**From:** Christopher Fraser <Christopher.Fraser@planning.nsw.gov.au>  
**Sent:** Monday, 31 May 2021 9:54 AM  
**To:** Grant Harlow  
**Subject:** S29/3/97-Mod-1 - Eastern Creek Karts, Departments design comments  
**Attachments:** Endeavour Energy.pdf

Following on from our discussions on design requirements on 26<sup>th</sup> and 28<sup>th</sup> May 2021 for the above please see the following notes for design work ;-

PMF Water Level (mAHD) and Depth (m) - Post Filling

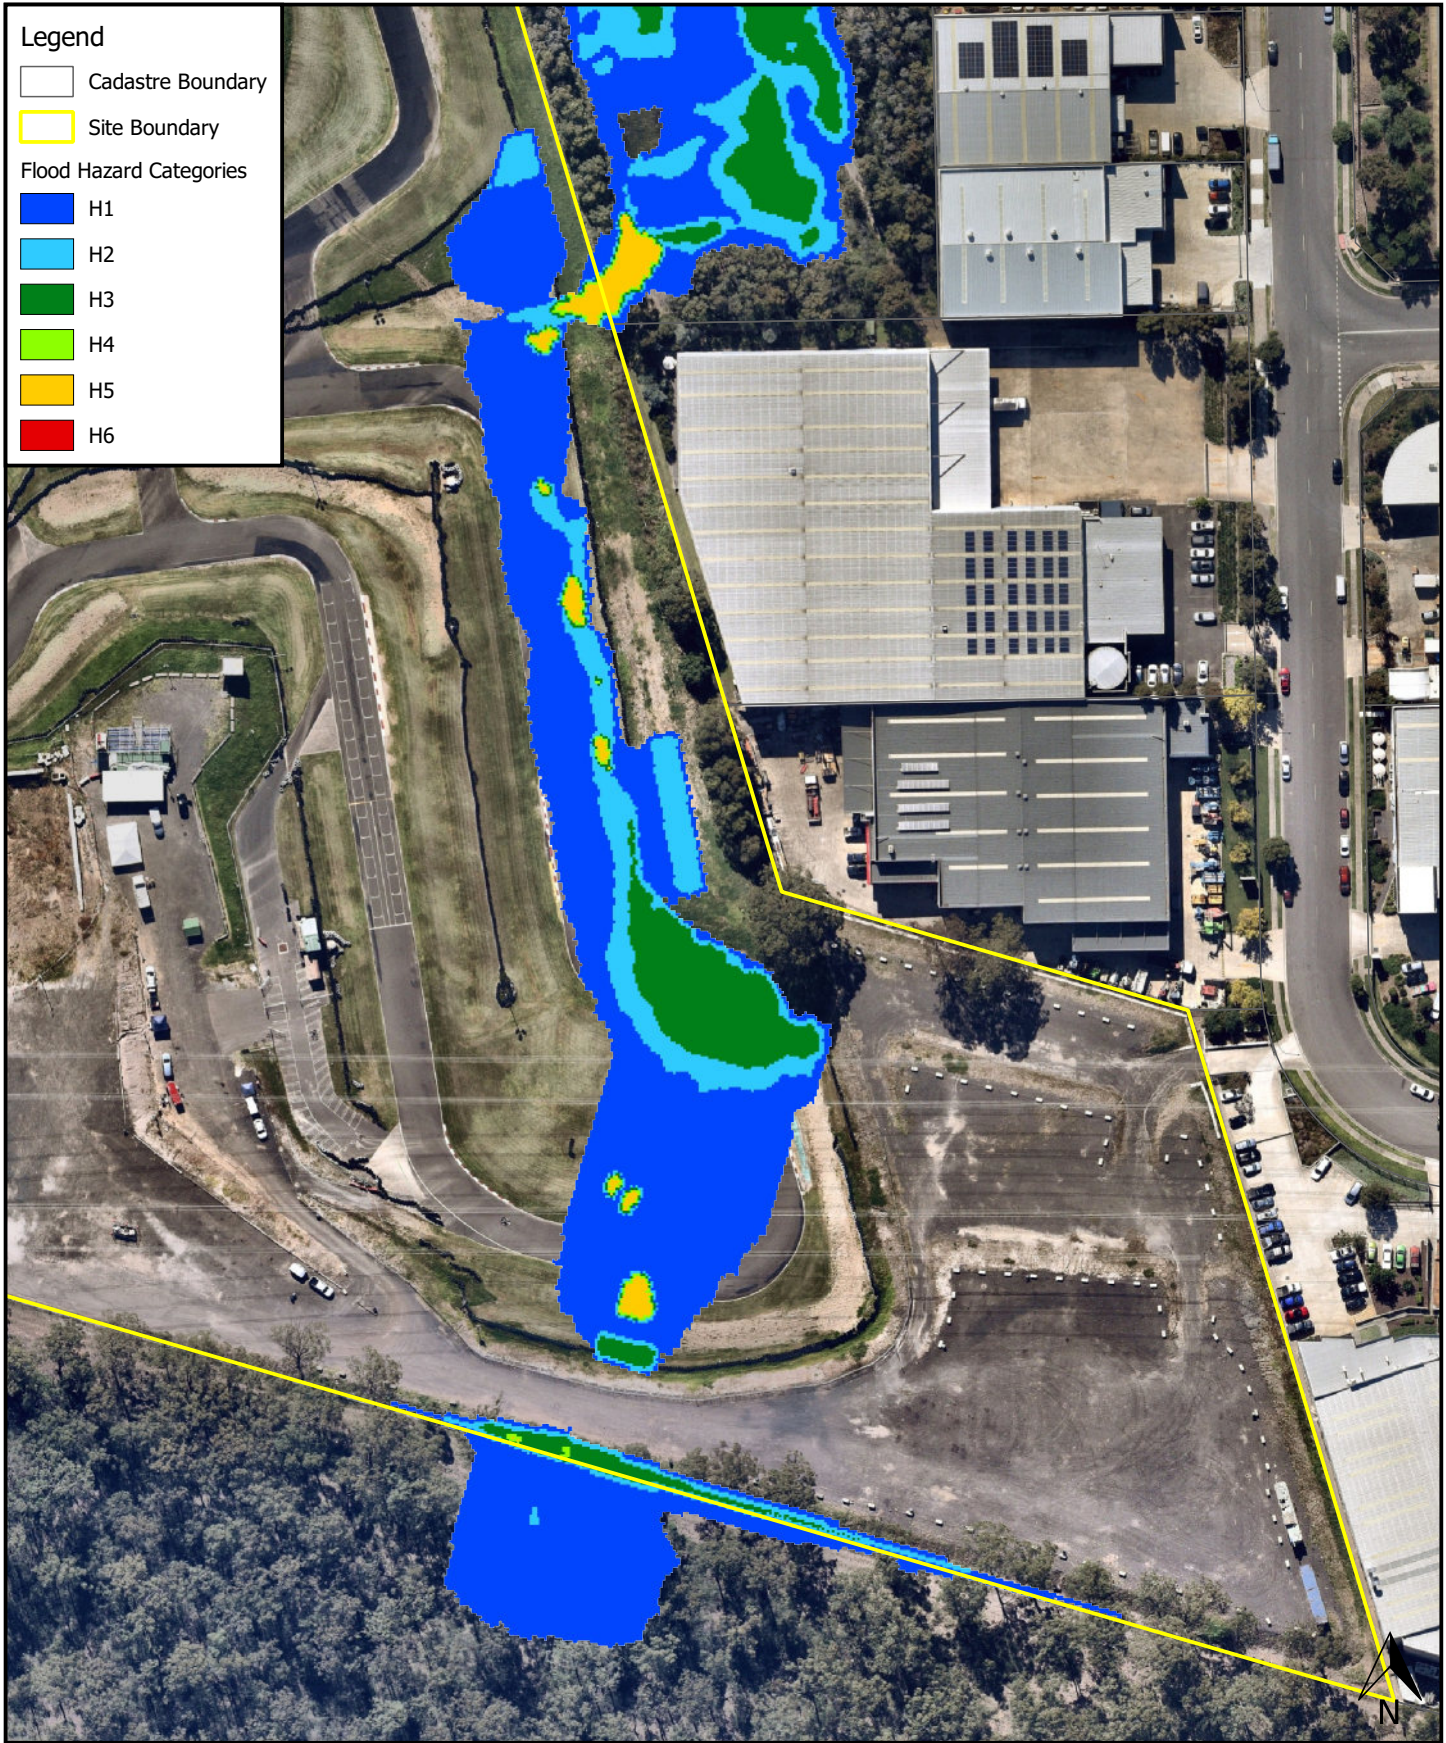
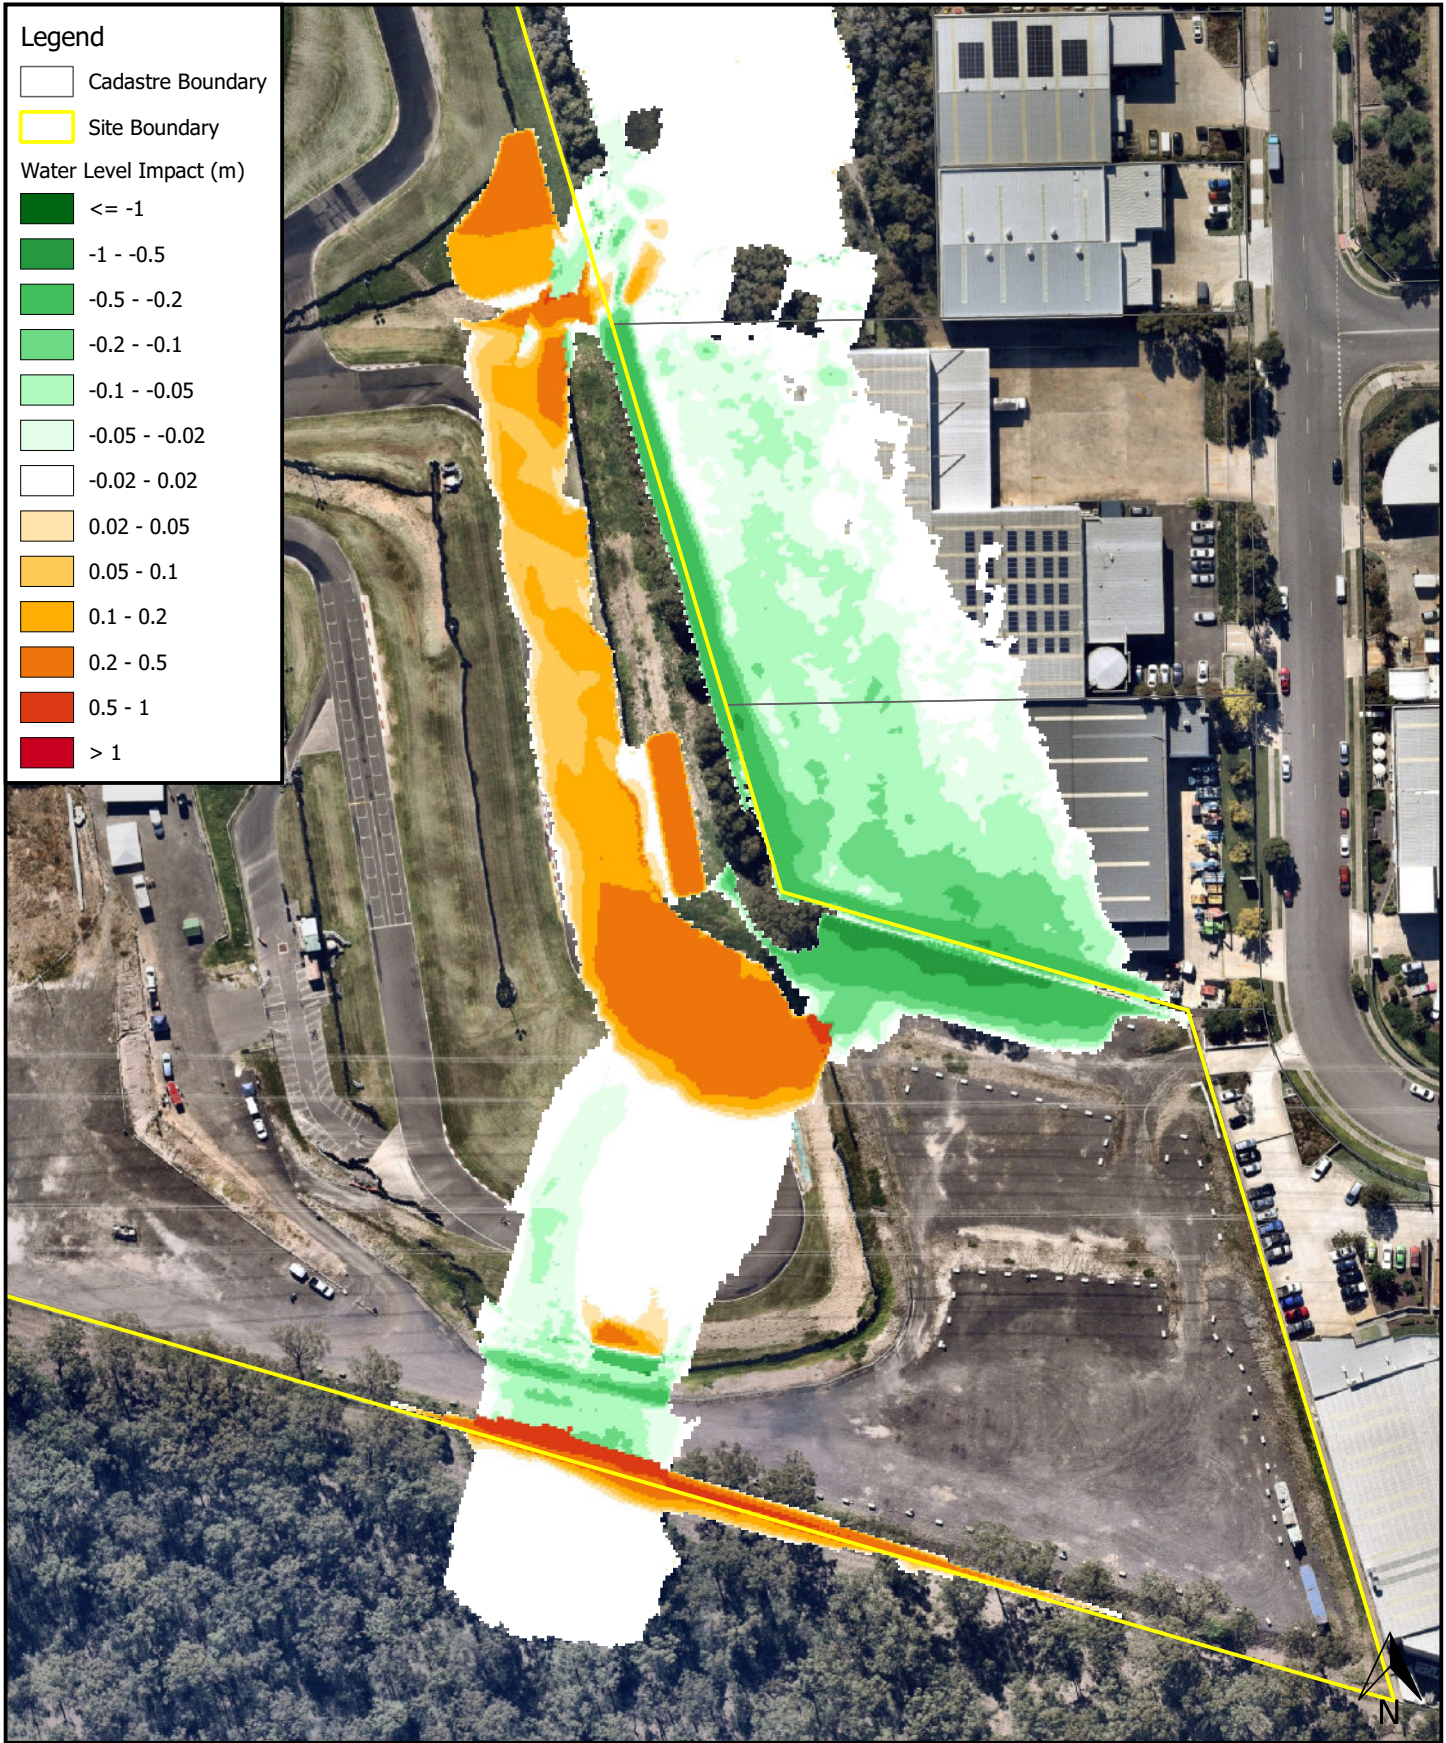
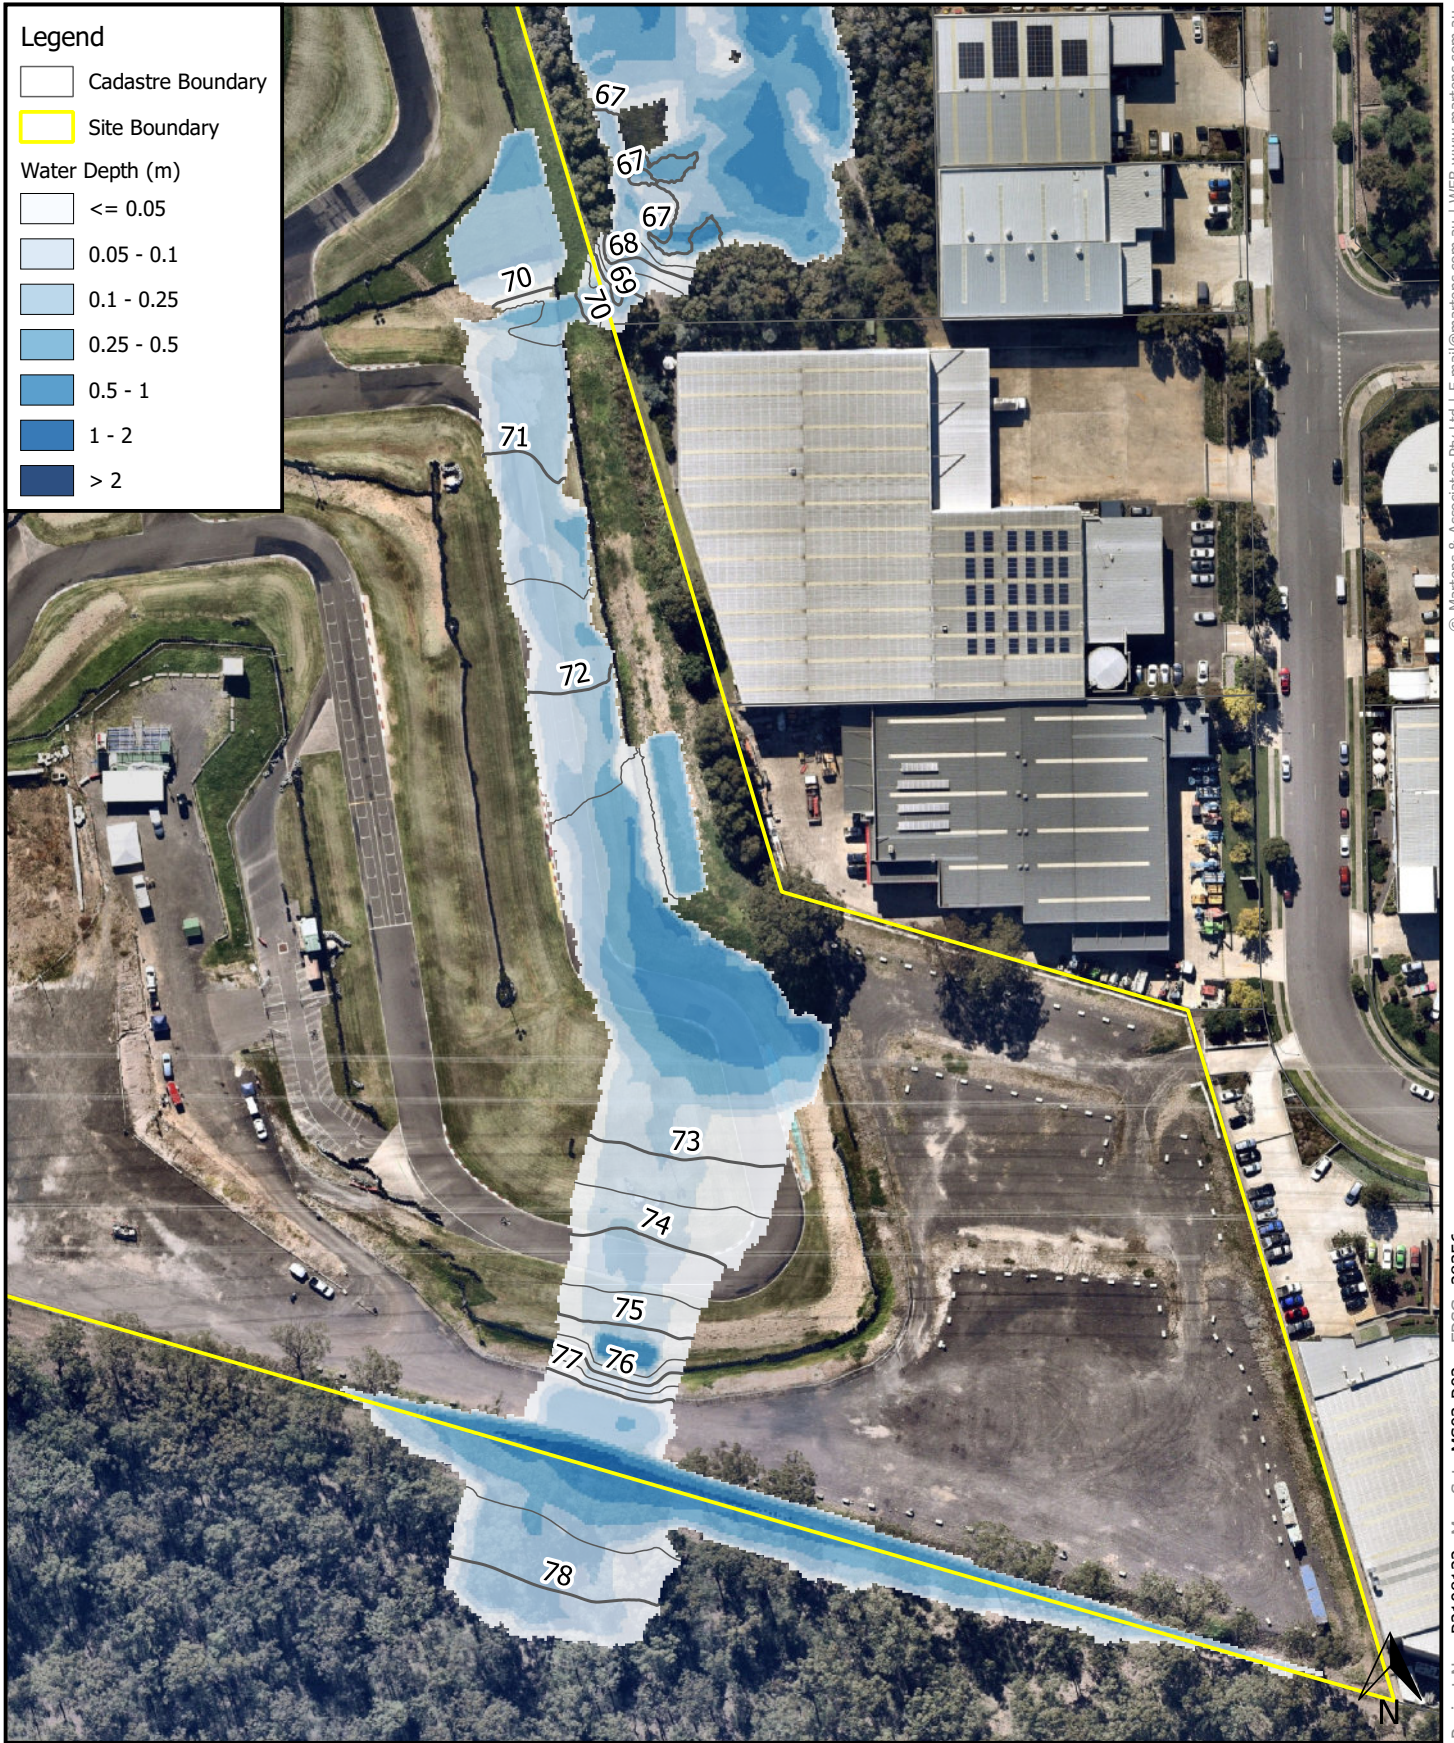
8. As example, the 100 yr ARI should be contained entirely within Karts land swales. A design check must be shown on TUFLOW output to ascertain impact on Prospect Reservoir land during the PMF, with preferably low hazard H1 results, to ensure constant and safe WaterNSW access on its perimeter road.
